110 O'Connor Street | Informal Pre-consultation | Site Plan Control Application | Groupe Mach, Geiger Huot Architectes, Fotenn Planning + Design

Key Recommendations

scale:	As indicated	drawn by:	E.H.
date:		approved by:	E.H.
drawn:	23-03-2024	drawing:	A-201

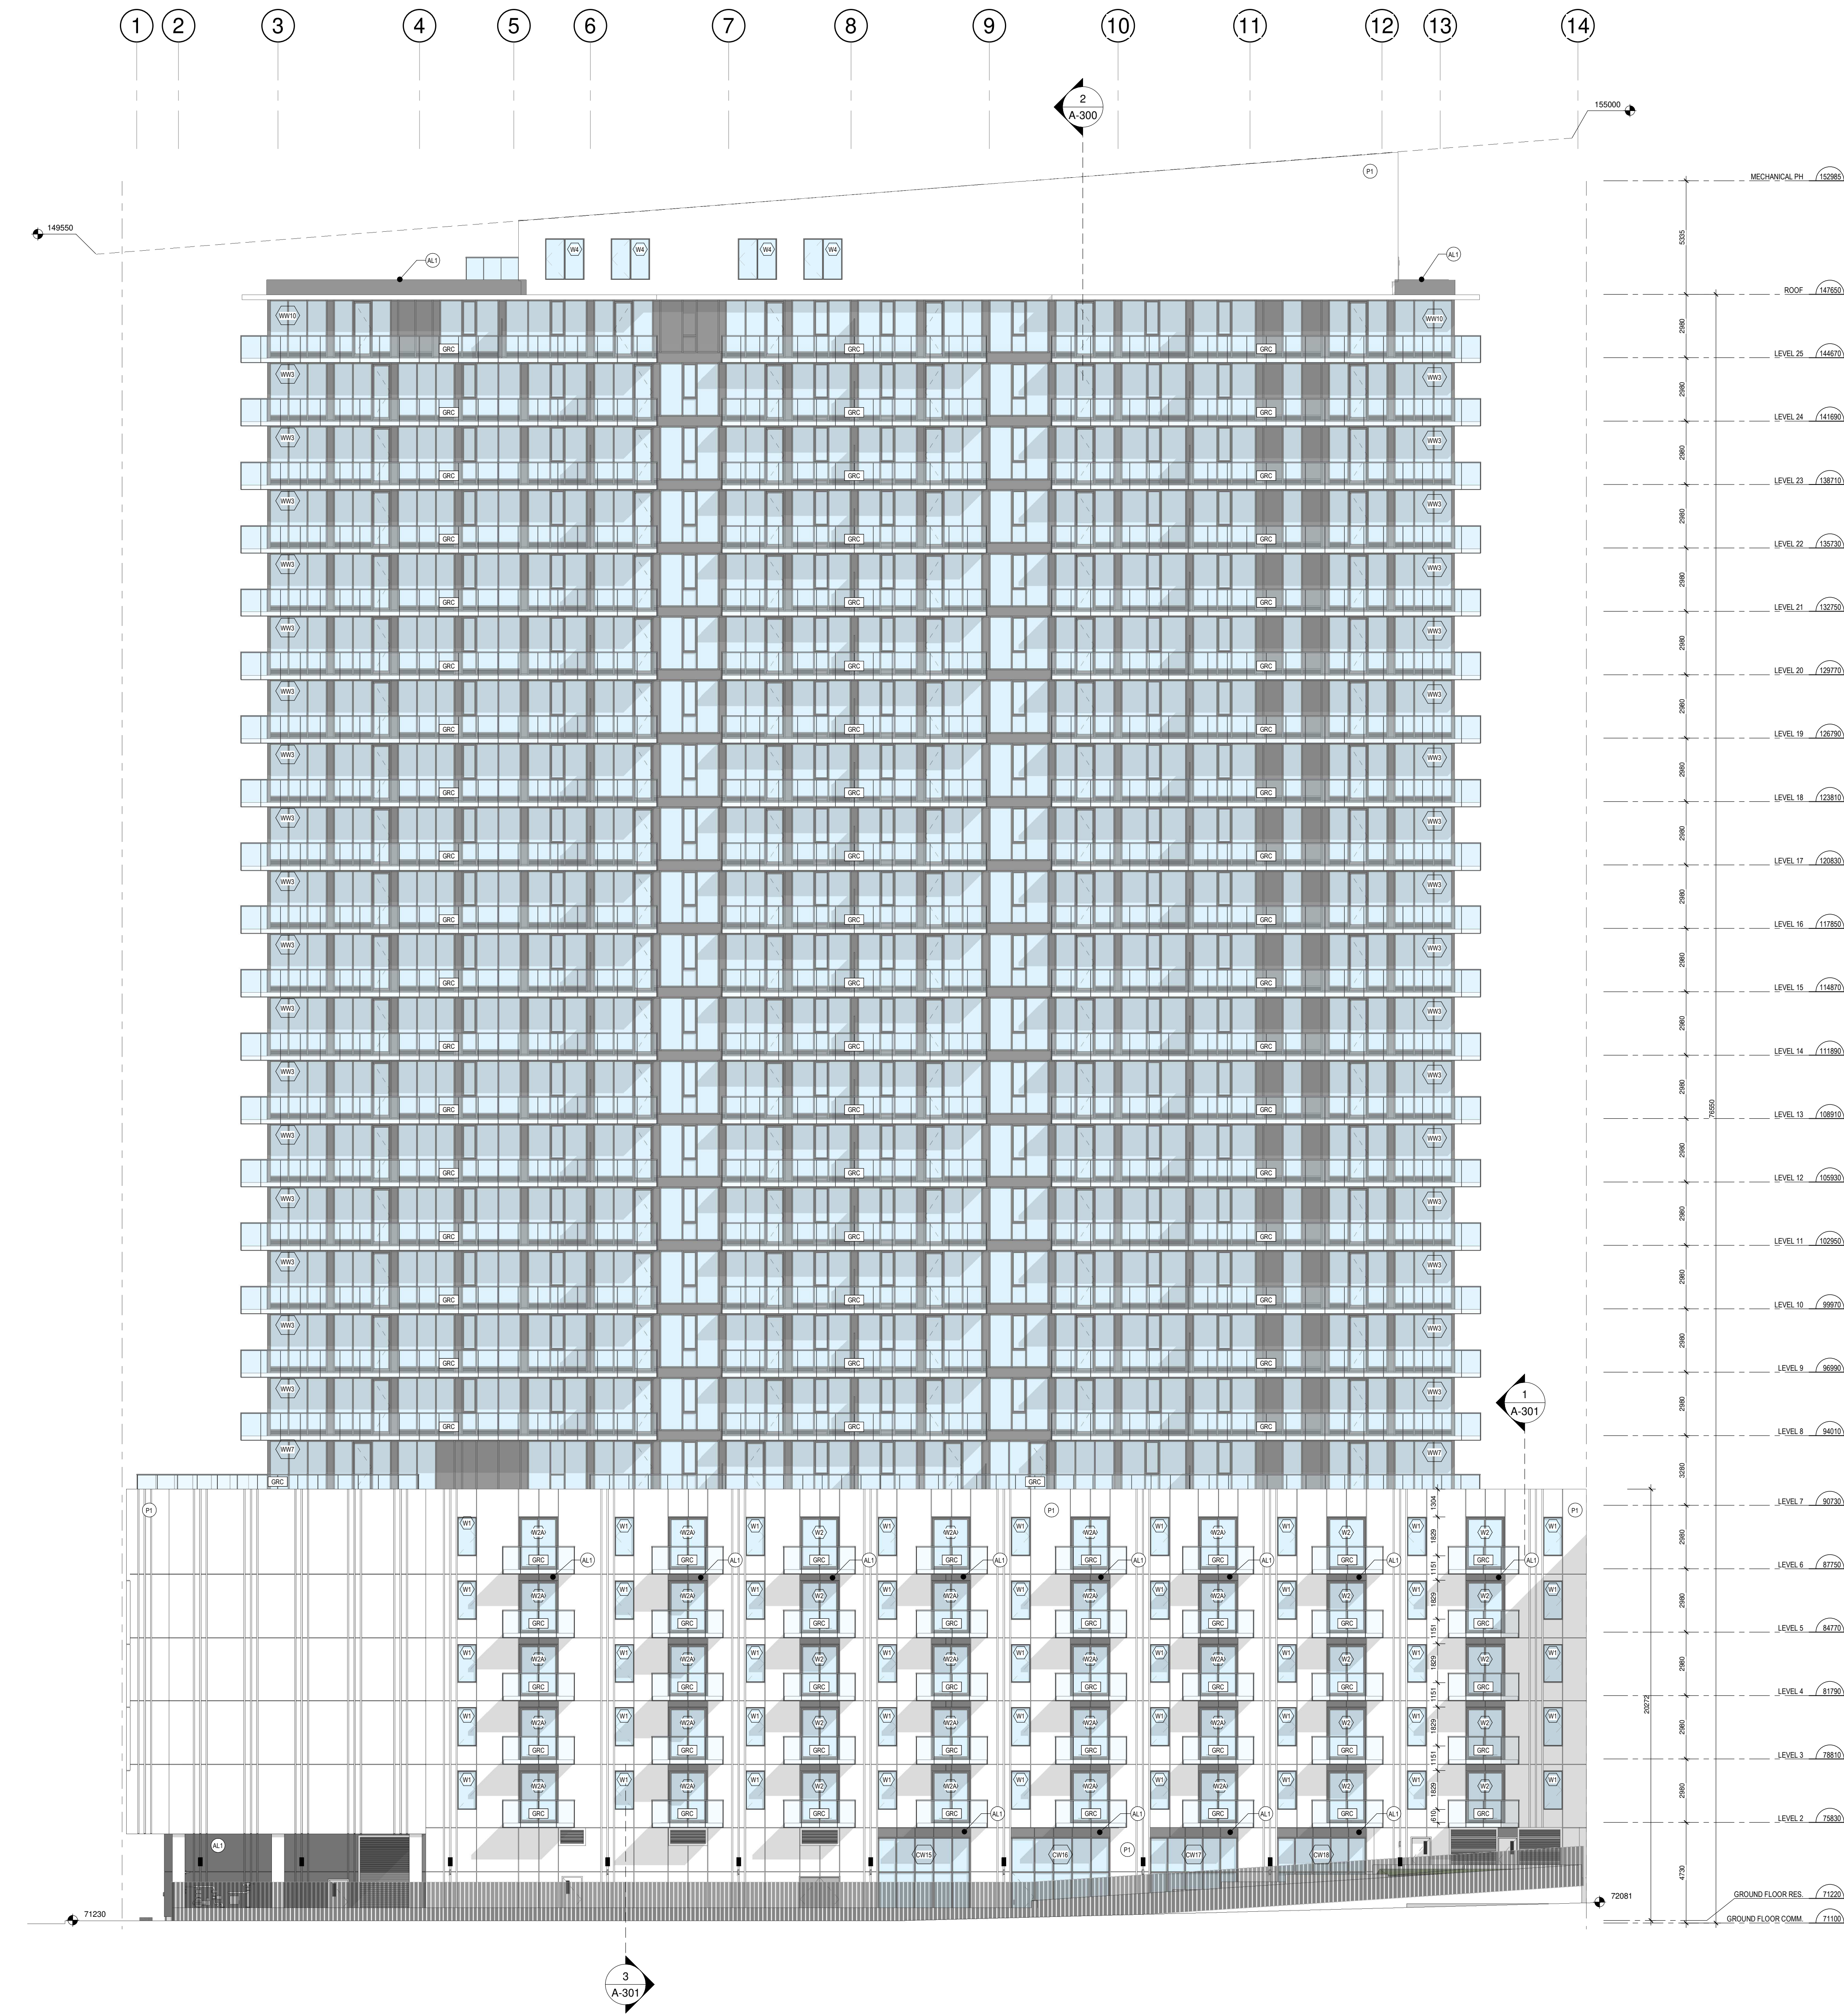
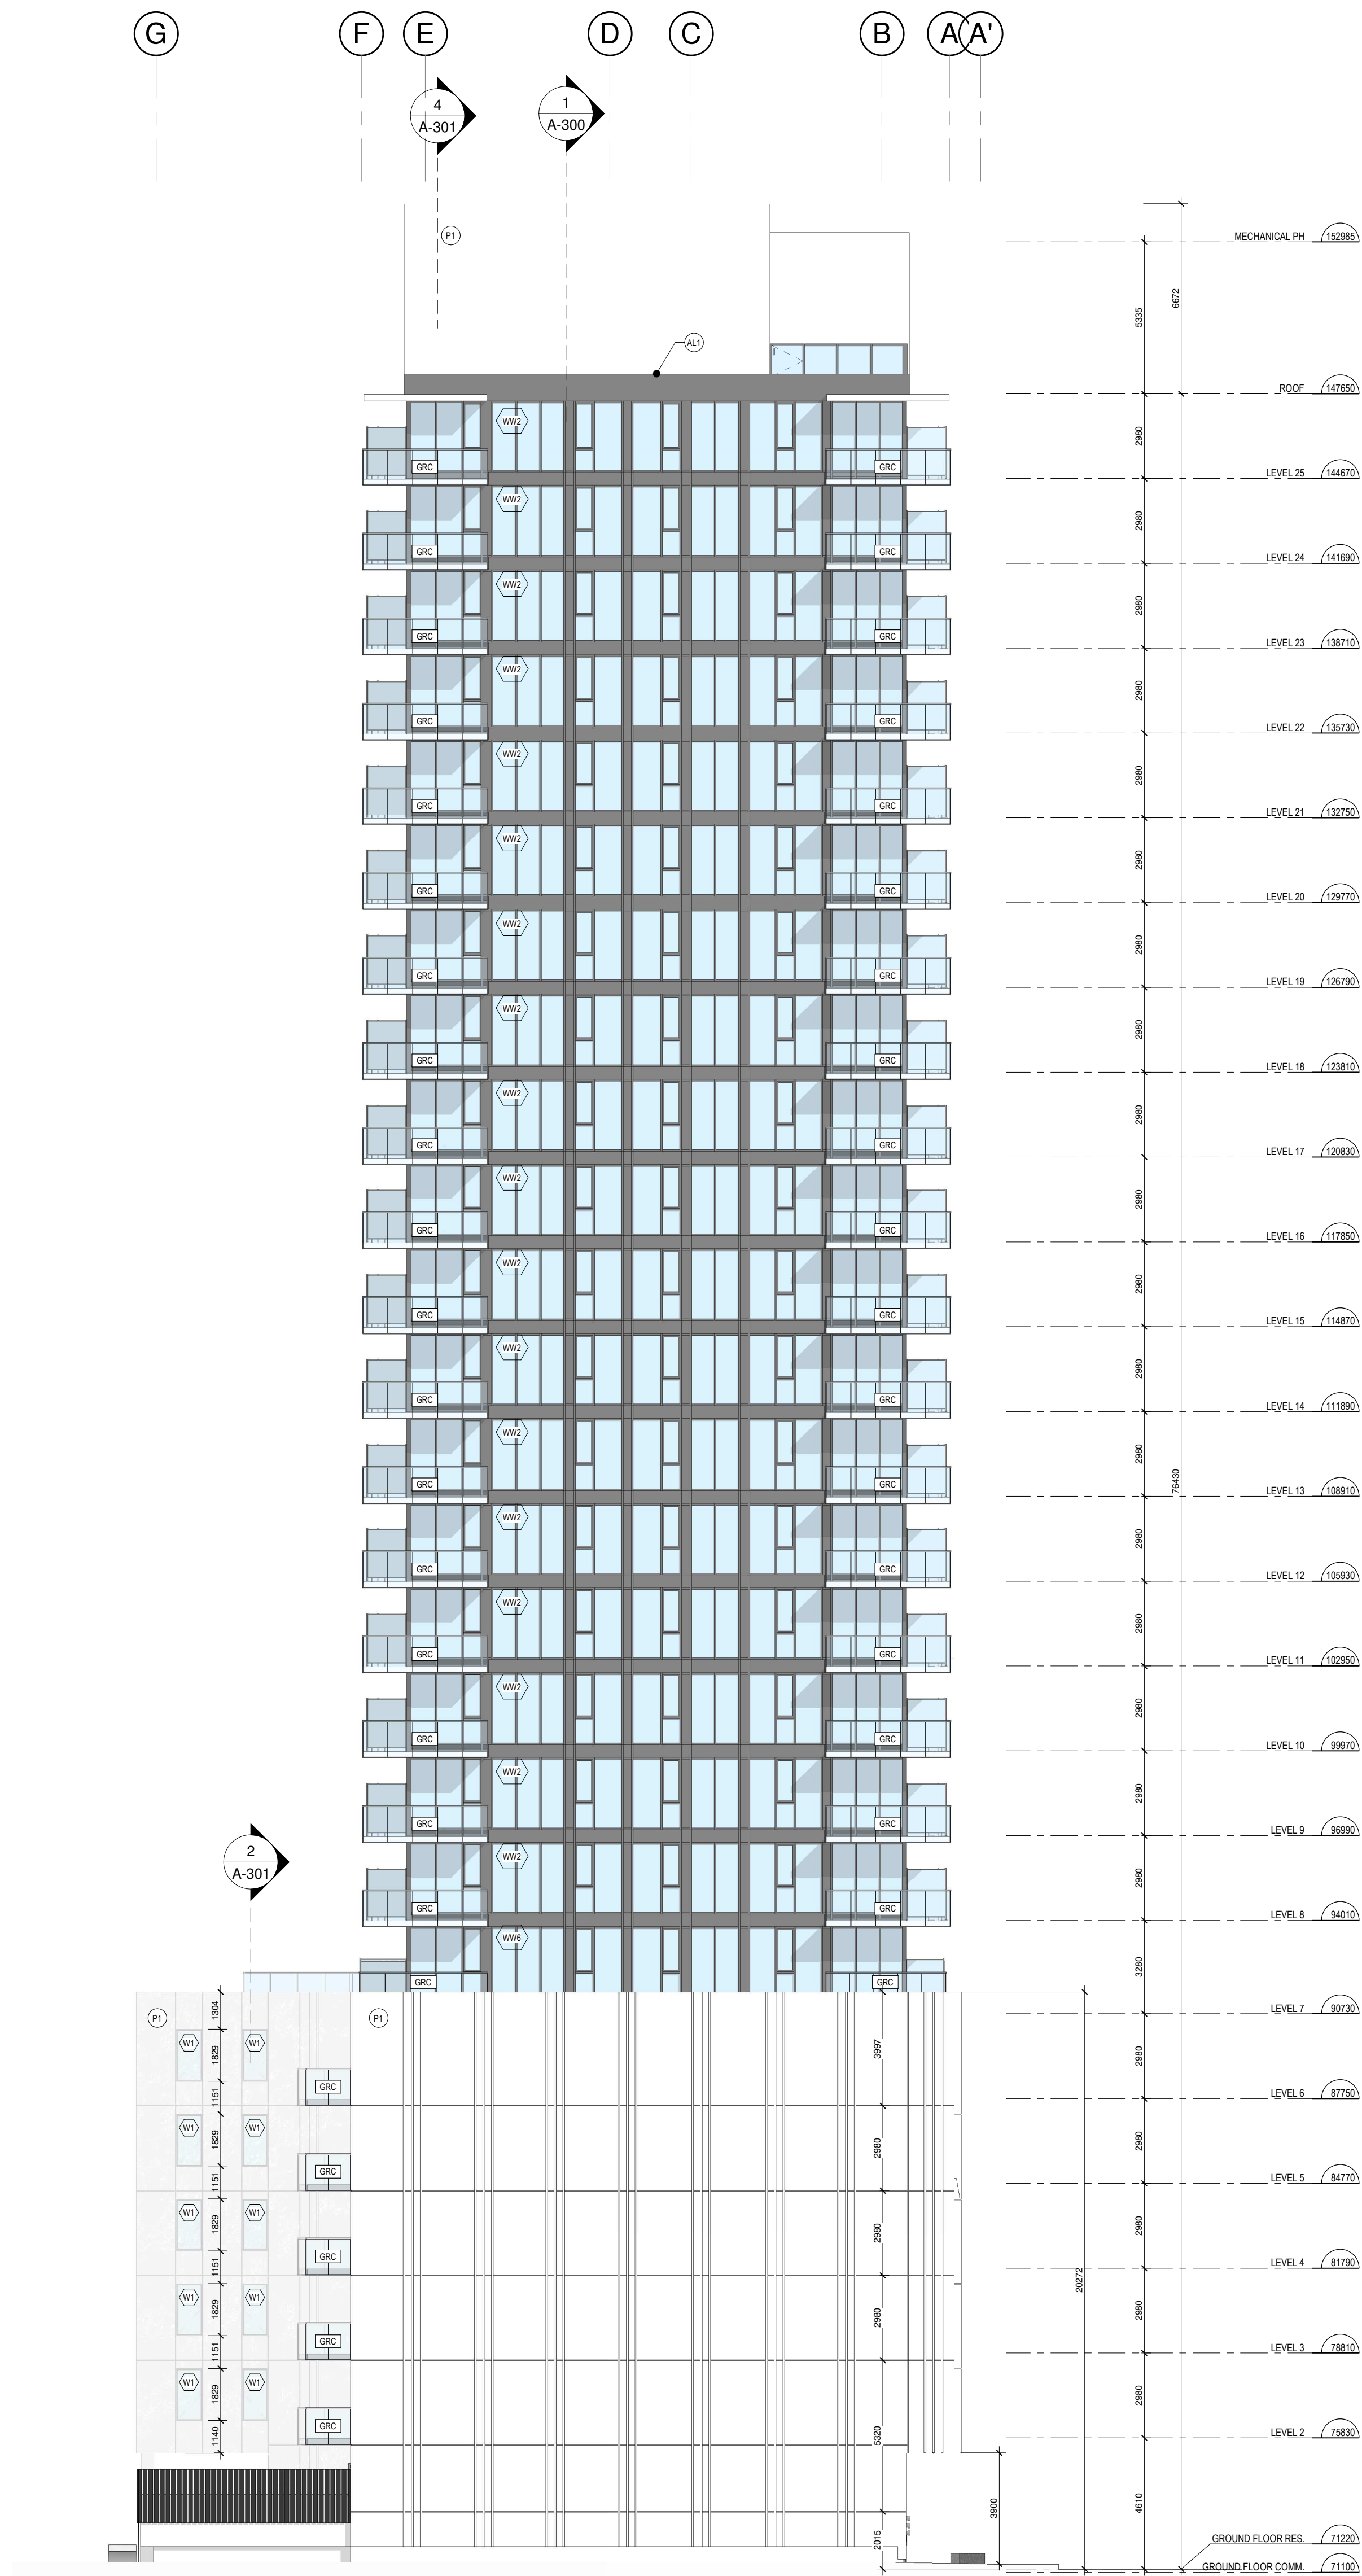
- The Panel supports the transition of land use and addition of residential units in the downtown core.
- The Panel has concerns with the 7.5 metre setback creating too tight a condition with adjacent sites and strongly recommends setting the building back a minimum of 10 metres from the property line.

- The Panel notes that the zoning downtown is very tight, which historically was provided for daytime office uses. Considering that this proposal is for a residential building, the amount of setback provided to the rear lot line needs to be re-thought. The current 7.5m setback is too small, and a minimum of 10m setback is needed in order to have a 20m separation from future adjacent towers.

ROOF PLAN

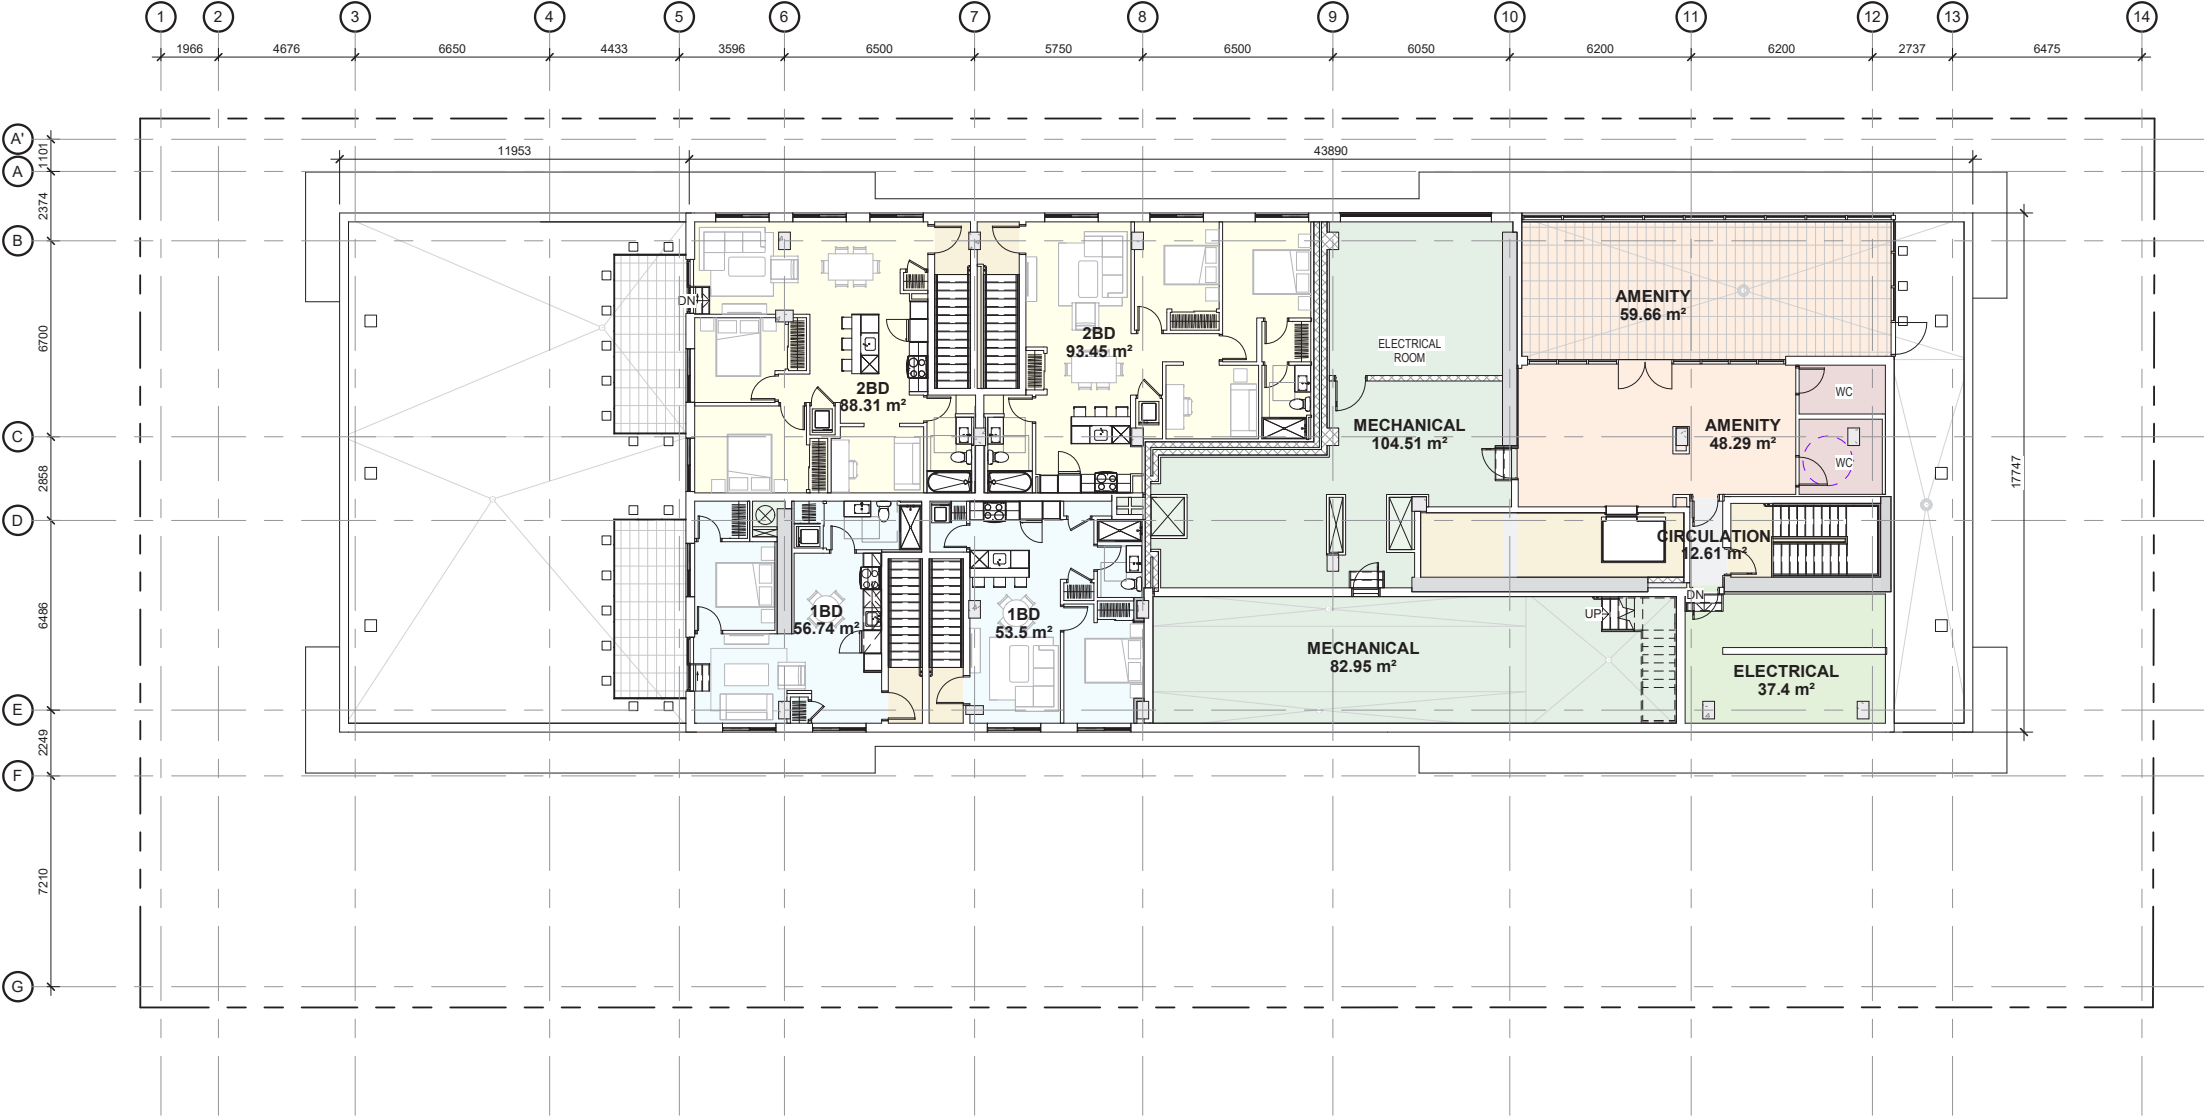
- The Panel appreciates the terracing of the outdoor amenity space to cover the parking ramp.
- The Panel has concerns with the overall lack of amenity space provided and recommends a more generous amenity should be provided at the top of the building.

- The Panel has concerns with how small the proposed mechanical equipment room is. More study is required to ensure adequate allocation of space for the rooftop mechanical equipment.

- The Panel recommends further exploring how the top of the building meets the sky, and recommends ensuring that the mechanical equipment room is concealed within the rooftop treatment.
